PLANNING AMENDMENT

H16/1049/02/A1

Adj Lyndale cottage, Cowbit Rd, Spalding

Change brick to Hanson Binbrook Multi

ELEVATIONS 1:100

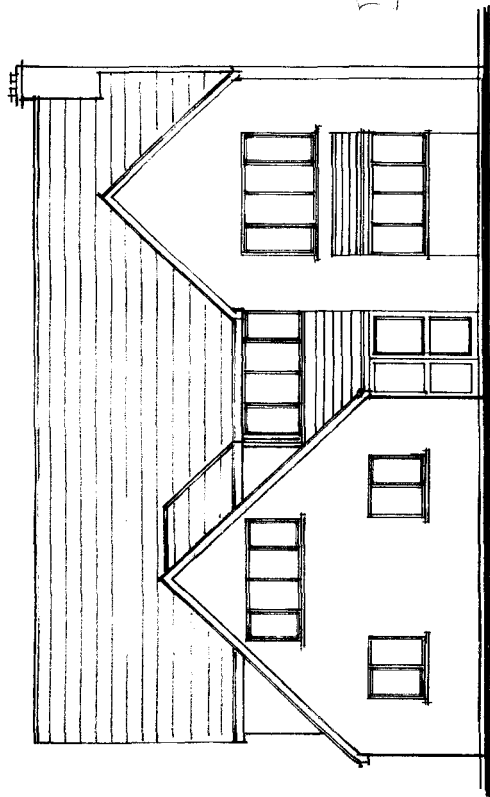
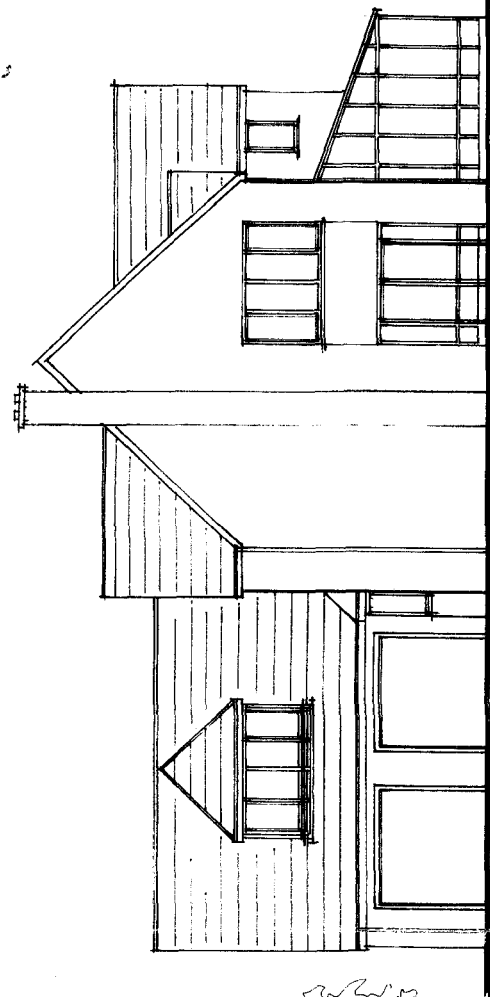
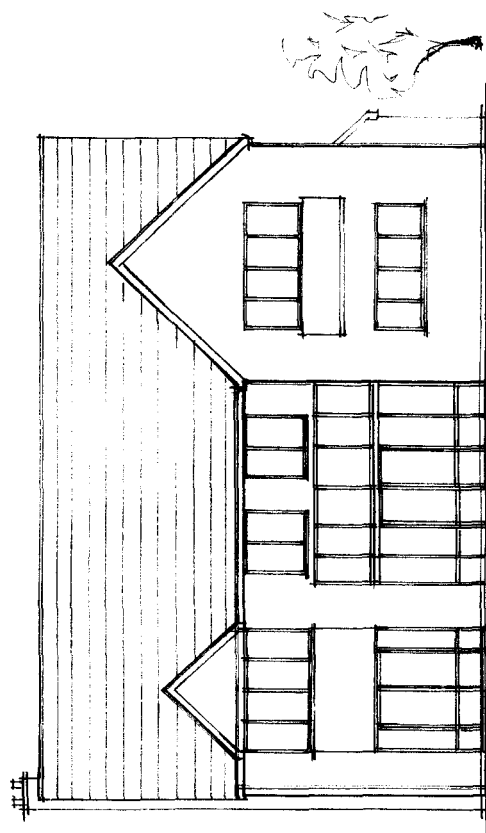
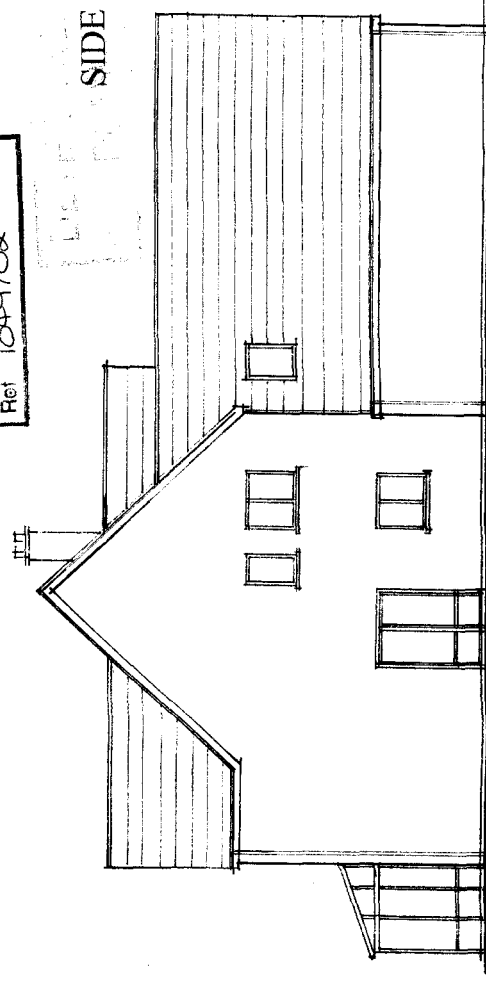
change Brick to
Hanson Binbrook
multi

Following our telephone conversation I am writing to amend the brick used in the above development from Corbusier blend to a Hanson Binbrook Multi from Jacksons. Please find enclosed a brochure containing details. If you require further details please contact me above.

The amended details submitted in respect of the above proposal have now been considered and there are no objections to the amendment being implemented to the extent described above.
